Thank you for the opportunity to comment on the environmental impacts of The Grove PUD Rezone (Z-06-14) application. In reviewing the application and relevant references, we have discovered that a **Determination of Non-Significance under SEPA would be completely inappropriate in this case.**

Inaccuracies in The Grove's Application for a
Planned Use Development and SEPA Checklist

Items are addressed in the order they appear in the "Notice of Application: The Grove PUD Rezone (Z-06-14)."

Revised site Plan July 7, 2006

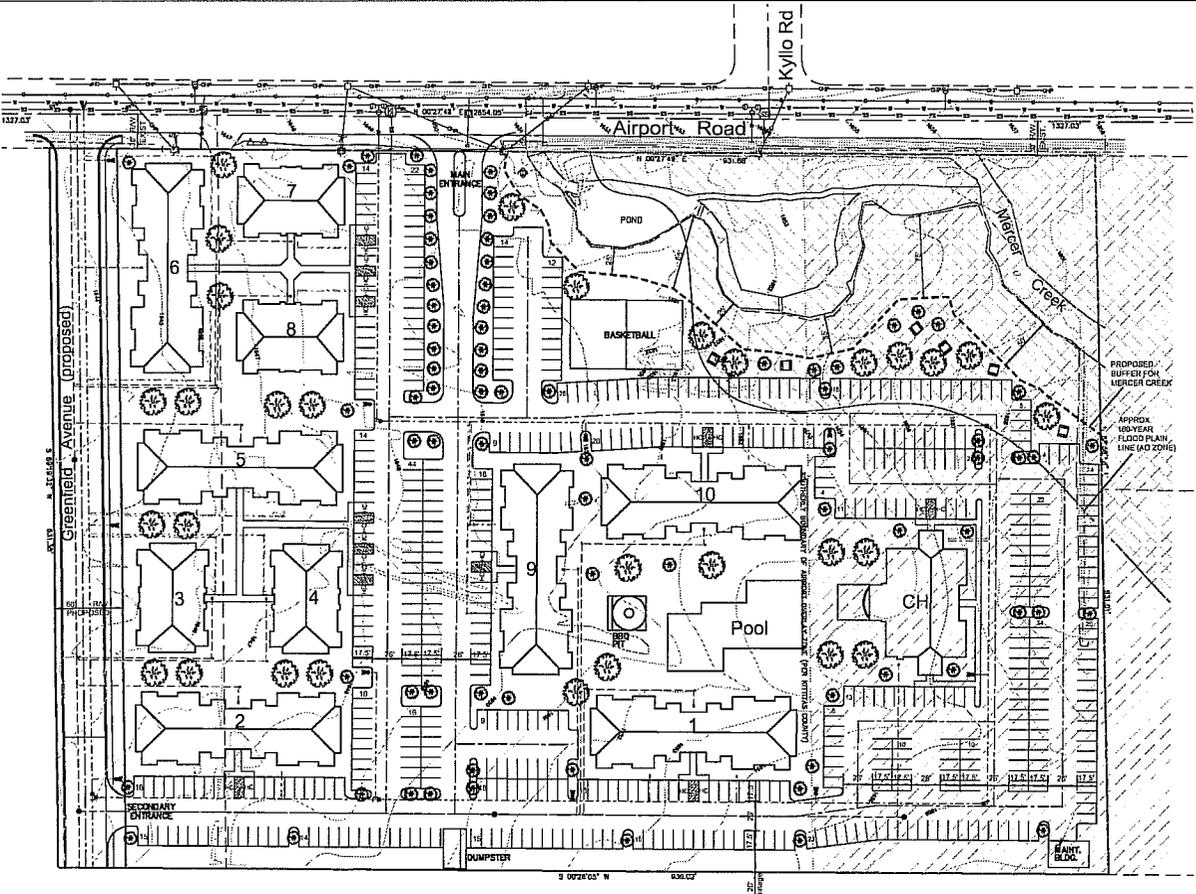
8. In the Preliminary Development Plan, item 3, *the application states that the area around Mercer Creek will be kept in a natural state.* The area is not natural now, but will certainly depart further from the natural condition if the creek and pond are filled in and replaced with volleyball courts and a clubhouse. Creeks do not naturally make right angles. Pictures of recent flooding of the Wolfe property (May 2006) clearly demonstrate the ‘natural’ course of Mercer Creek as it currently exists. The photo in the bottom-left shows the supposed ‘main channel’.

- During the flooding of late May and early June this year approximately 80% of Mercer Creek's flow traveled through the channel that is proposed for filling. There would be significant hydrologic impact from the proposed actions. This alone should eliminate any possibility of a Determination of Non-Significance, and require the preparation of an environmental impact statement.

10. Preliminary Development Plan, item 8: see point 5, above, regarding the Airport Overlay Zone. The net acreage is effectively 9 (approximately) for a density of 21.3 du/ac.
